Subject: Invalid Letter 21/01543/F

GROUND FLOOR PLAN

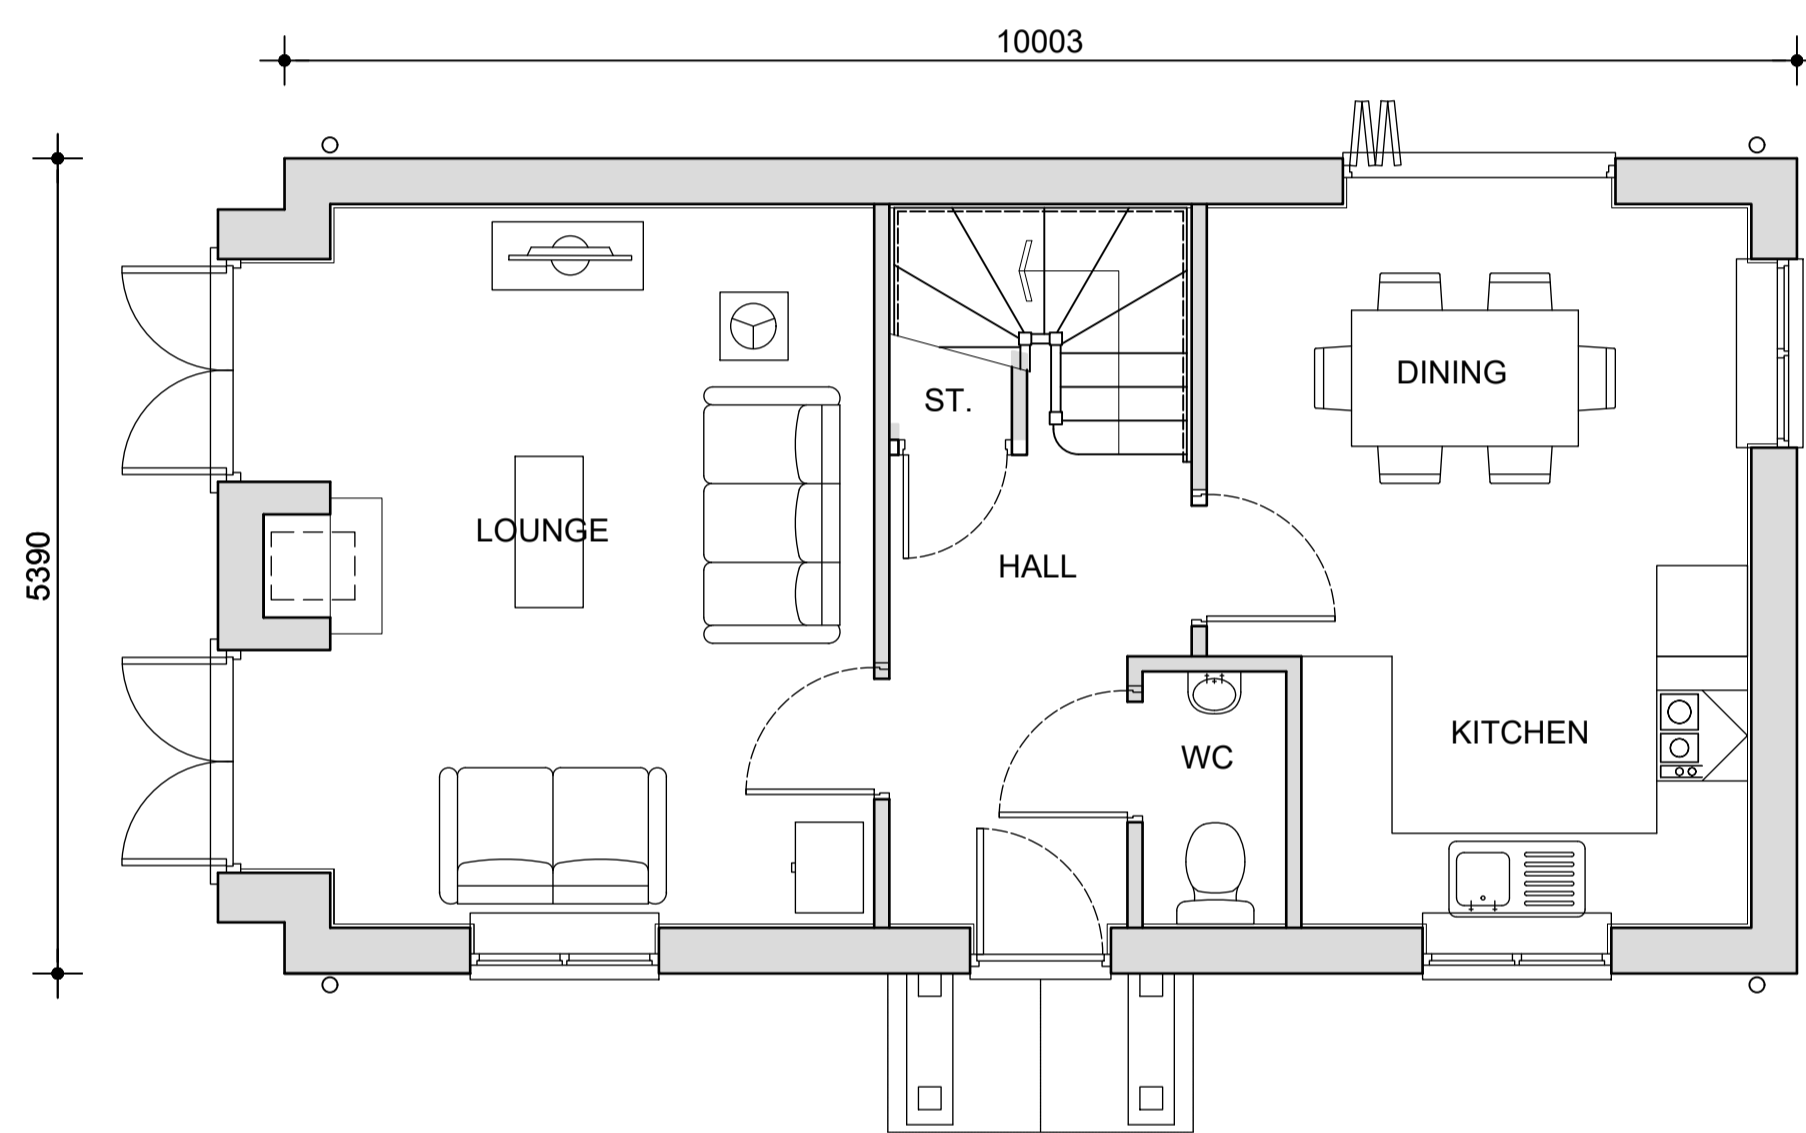
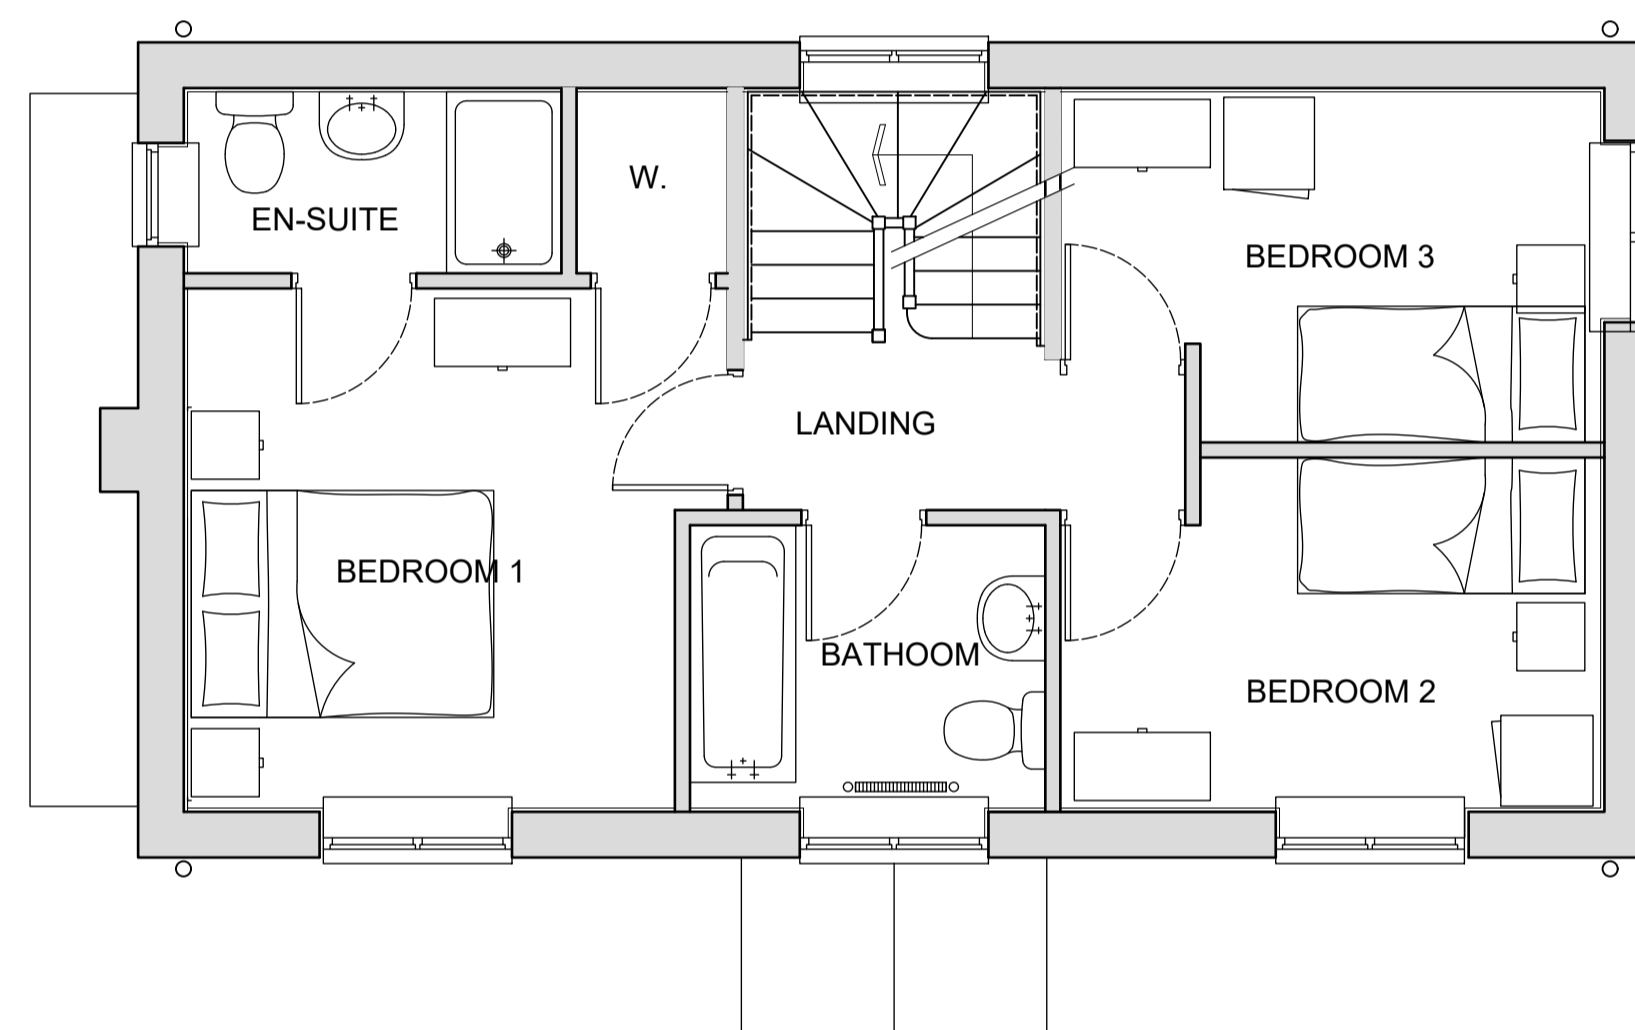
1. Contaminated Land Questionnaire (unfortunately, this wasn't attached to your email as stated?)
2. Habitat Fee (refundable on request, should the application be refused)
3. Flood Risk Matrix (editable version attached).
4. Section-through new dwelling
5. Item 7. On my colleagues email (slight error on the proposed ground floor plan)

SECTION

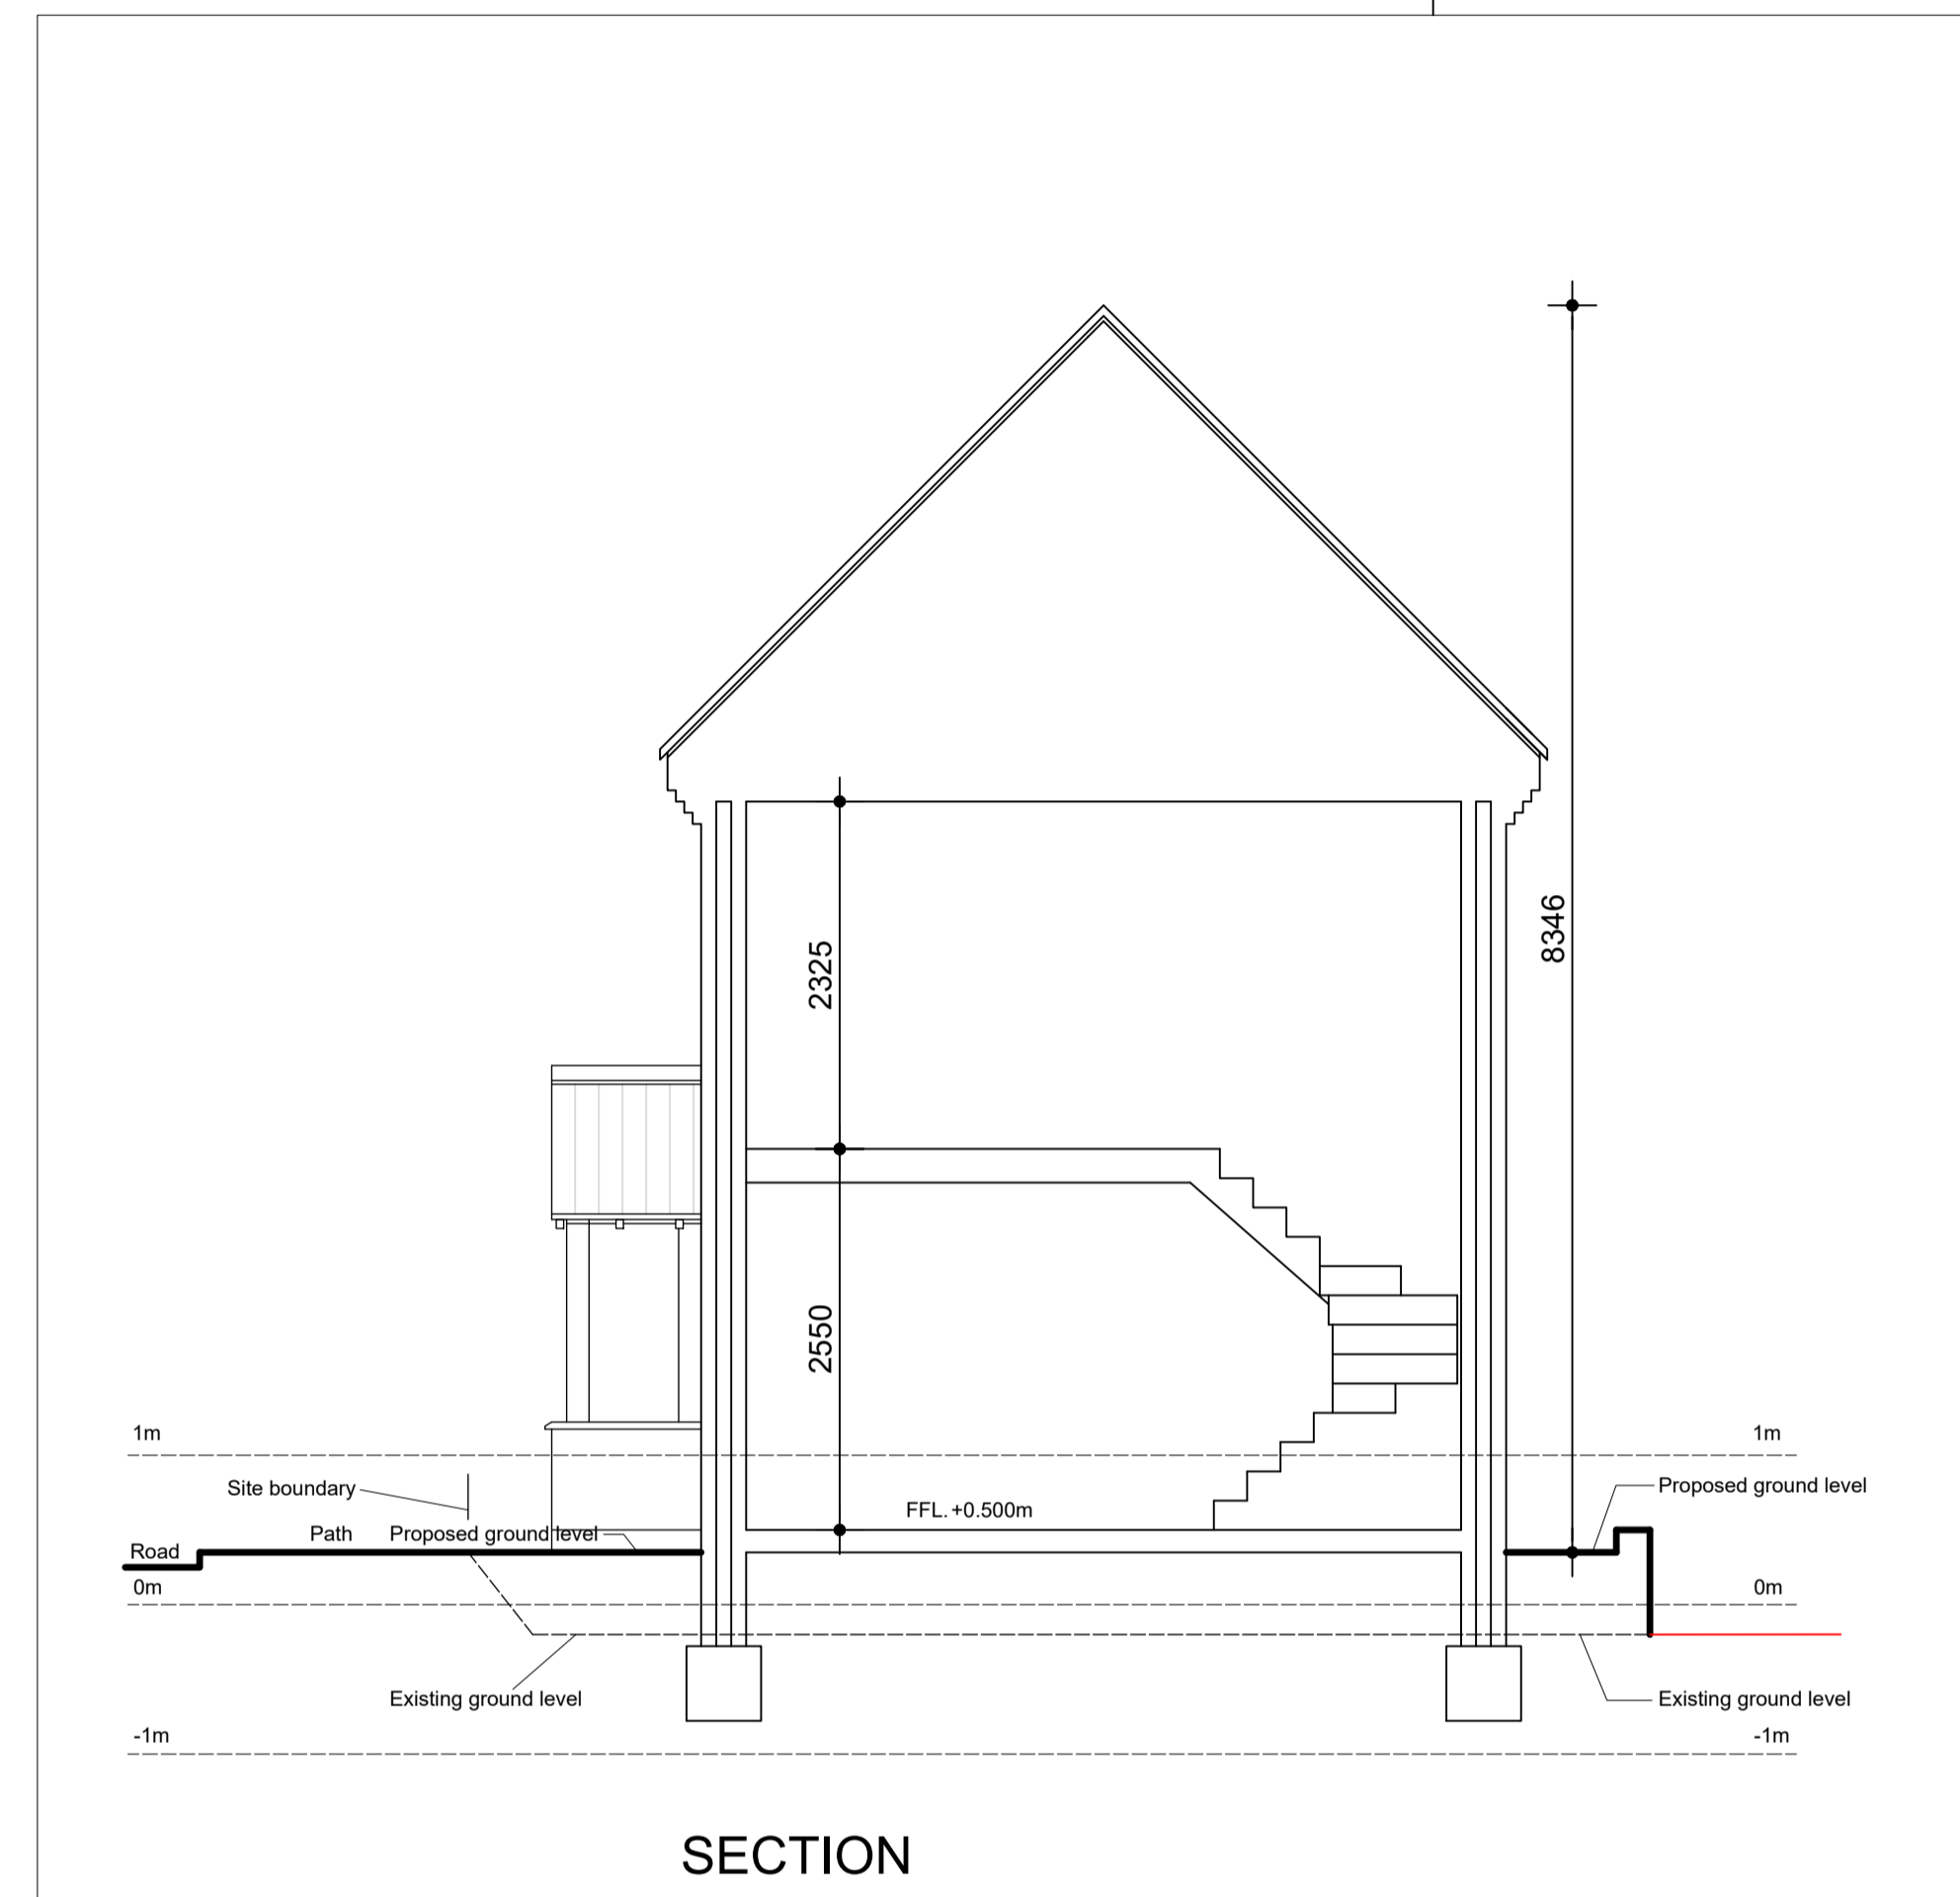
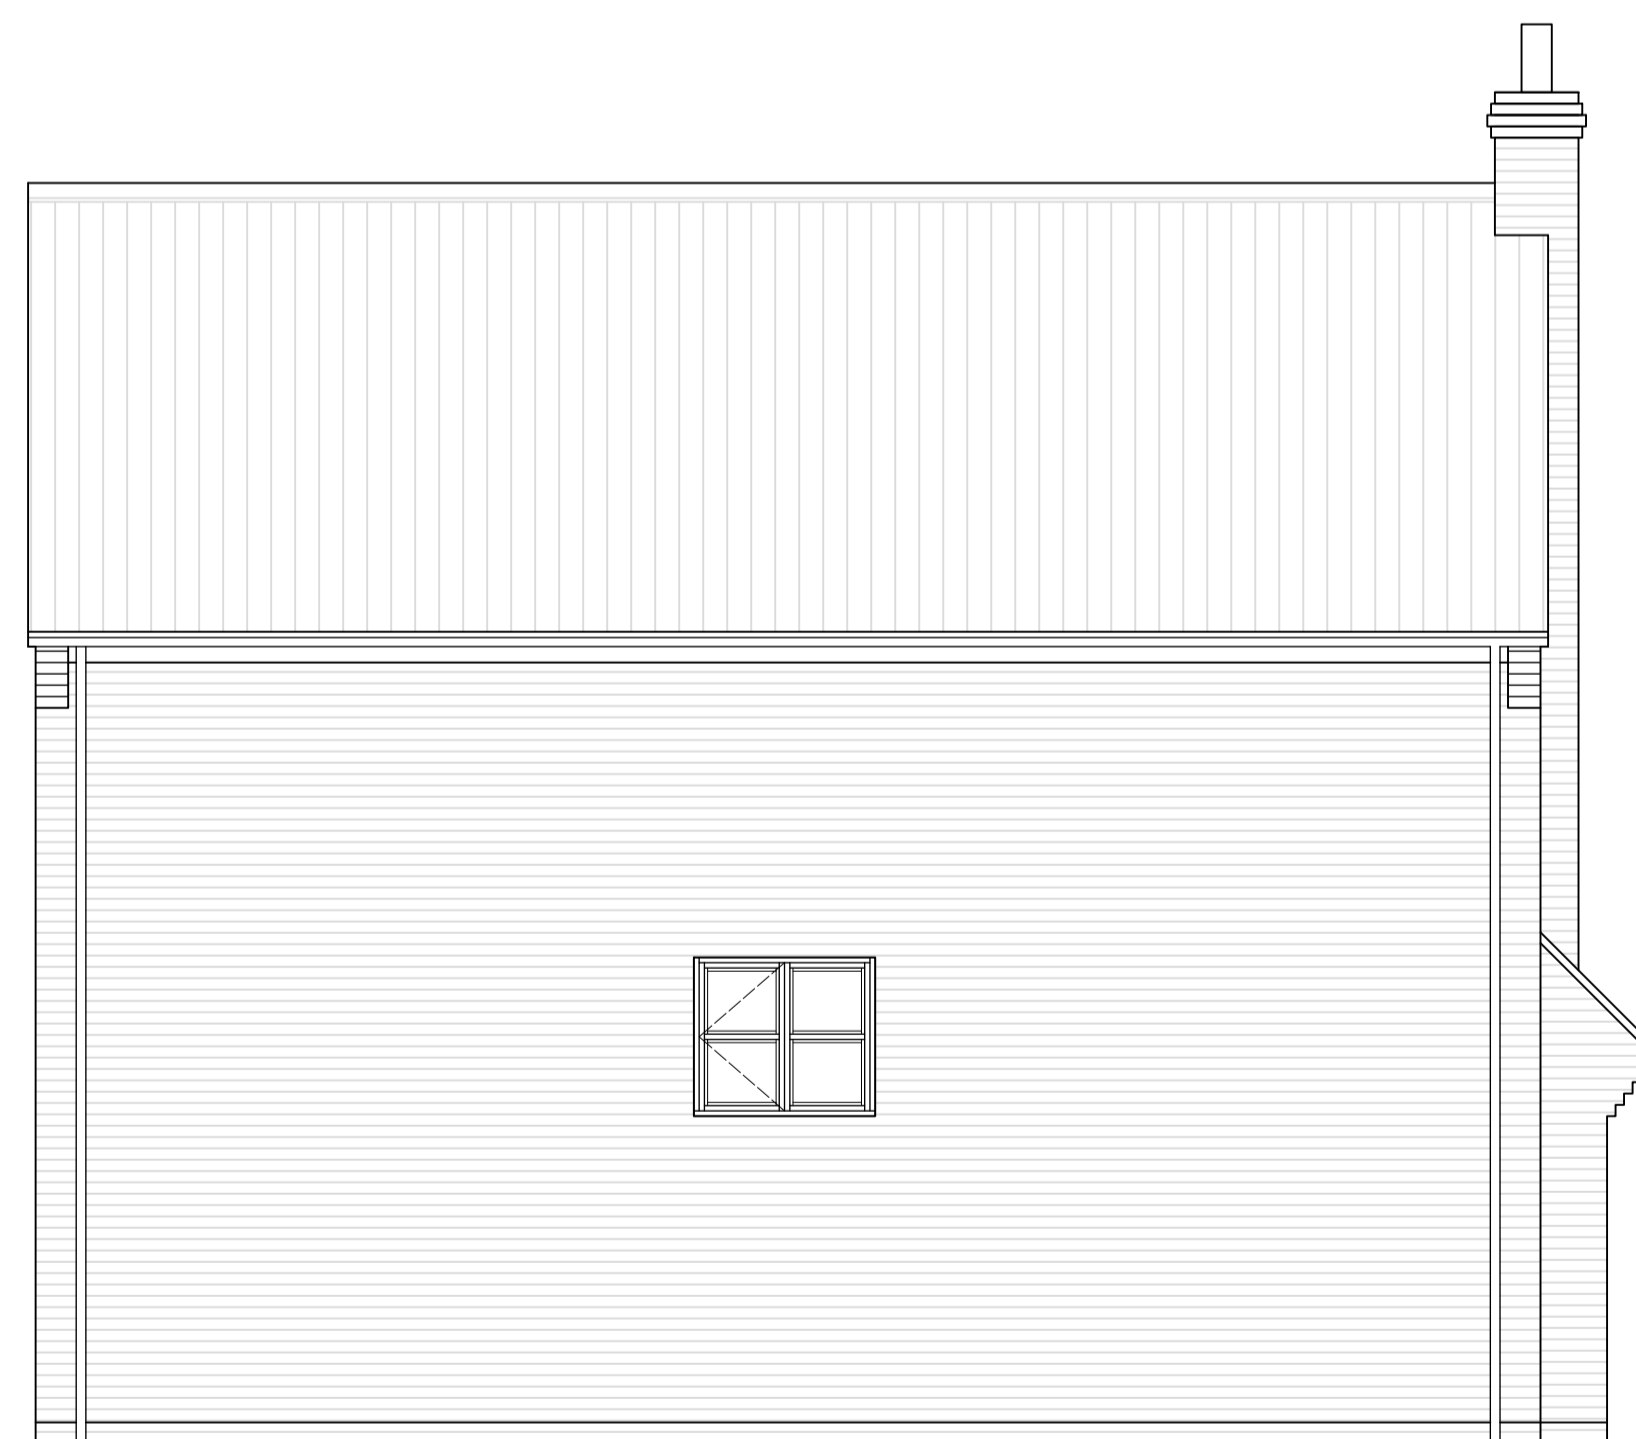
4. In addition to the FRA, please complete the attached simplified Flood Risk Matrix. The site lies within Flood Zones 2 and 3A and is subject to Tidal Breach. **Do you have an editable version or word document please?**
5. I require a section through of the proposed dwelling, in order to ascertain finished floor levels.

Please refer to the sections provided in the extant 2015 application. The levels remain as shown in this drawing. **This permission can and has been implemented. An application to make the required changes could have been submitted under s73, however, the applicant has opted to make a full application. The 2015 has commenced within the time frame required.**
